Thanet Extension Offshore Wind Farm

Statement of Common Ground – Estuary Services Limited

Submitted by ~~Vattenfall Wind Power Ltd~~ Winckworth Sherwood LLP on behalf of Estuary Services Limited

Date: ~~January~~ February 2019

Figure 3: PLA Simulator extent (ESL Pilot Launch tracks also shown - demonstrating area of activity for North East Spit Station).

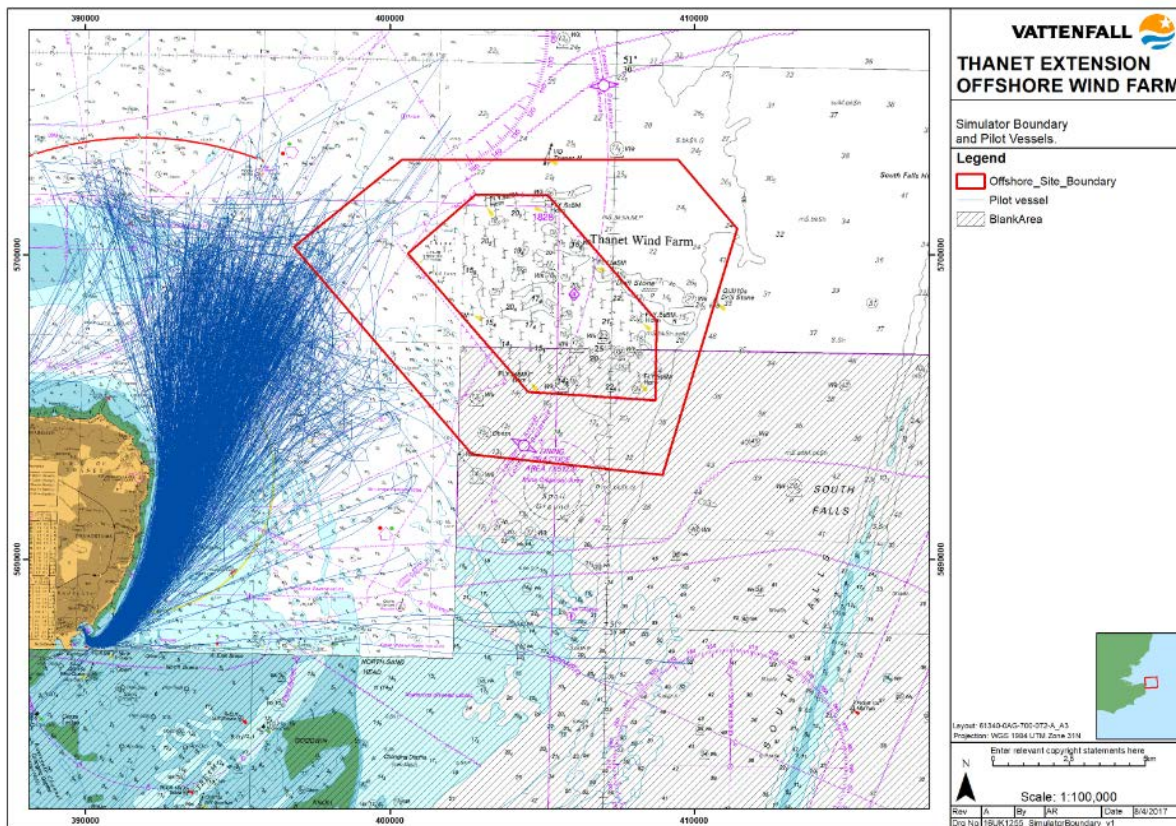
| Discussion Point | Thanet Extension Position | ESL Position | Final Position |
|-----------------------------------|--|---|----------------|
| <p>Accompanying documentation</p> | <p>It is agreed that the bridge simulation exercise (Application Ref 6.4.10.2) accurately reflects presents the effects on pilotage associated with the original Red Line Boundary.</p> | <p><u>Not agreed:</u> <u>ESL do not agree that the simulation exercise accurately reflects the pilotage operation at the North East Spit for reasons previously explained</u></p> | |

Sea Zones Plan – Reduction in red line boundary

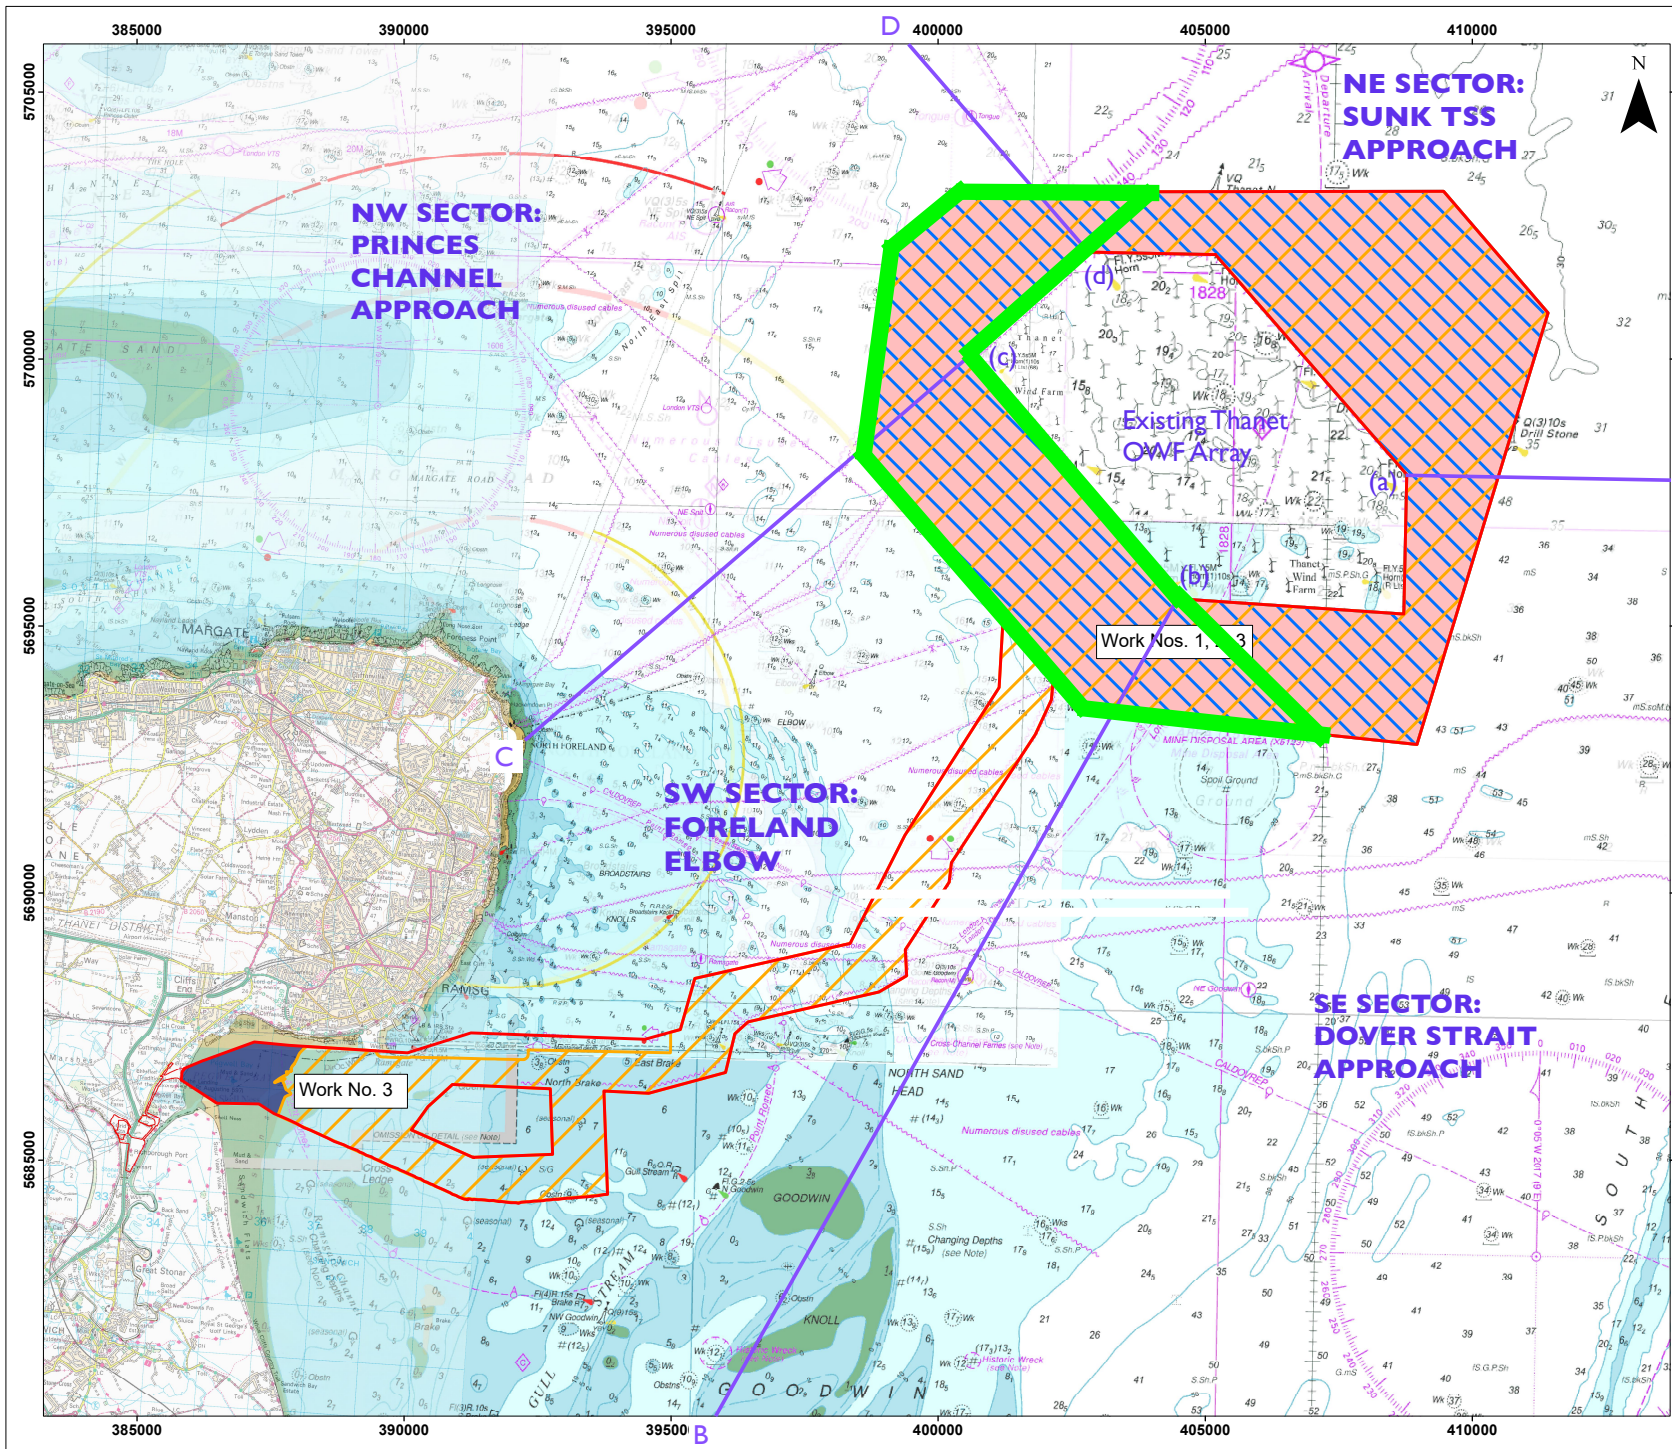
| Discussion Point | Thanet Extension Position | ESL Position | Final Position |
|----------------------------|---|---|----------------|
| Red Line Boundary revision | It is agreed that the revision made to the red line boundary following Section 42 consultation reduces interaction in the primary area of concern. | <u>Not agreed:</u> <u>Whilst ESL acknowledges that any red line boundary reduction would reduce interaction we do not agree that the current reduction addresses our primary area of concern. For clarity, the reduction in the RLB was not proposed by ESL.</u> | |
